From: Contact Centre (CRM) <contact@ribblevalley.gov.uk>
Sent: 01 December 2025 21:23
To: Planning
Subject: Planning Application Comments - 3/2025/0912 FS-Case-770179242

Planning Application Reference No.: 3/2025/0912

Address of Development: Barn adjacent to The Newdrop, Stoneygate Lane, Ribchester, PR3 2XE

Appendix A Site Plan

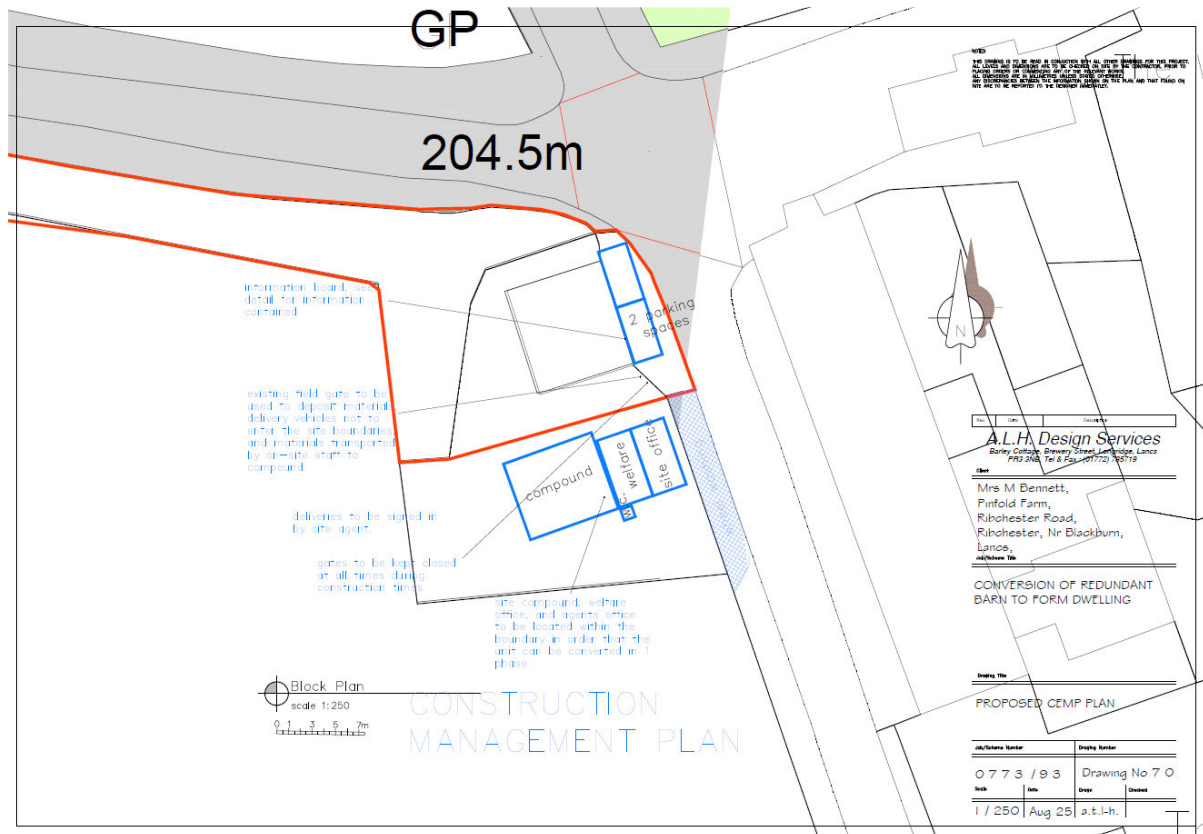
Comments: As a regular traveller through the crossroad junction at the site of the development property I wanted to ensure that the plans submitted do not increase the risk to other road users as well as the owners of the development. In particular the construction management plan makes provision for 2 car parking spaces to the side of the barn immediately adjacent to Stoneygate Lane. I am concerned that cars manoeuvring in and out of these spots may increase the risk of incidents / accidents as other vehicles pass quickly up and down Stoneygate Lane or join from Higher Road / Clitheroe Old Road. The formal planning consent does not allow for vehicle parking in this location.
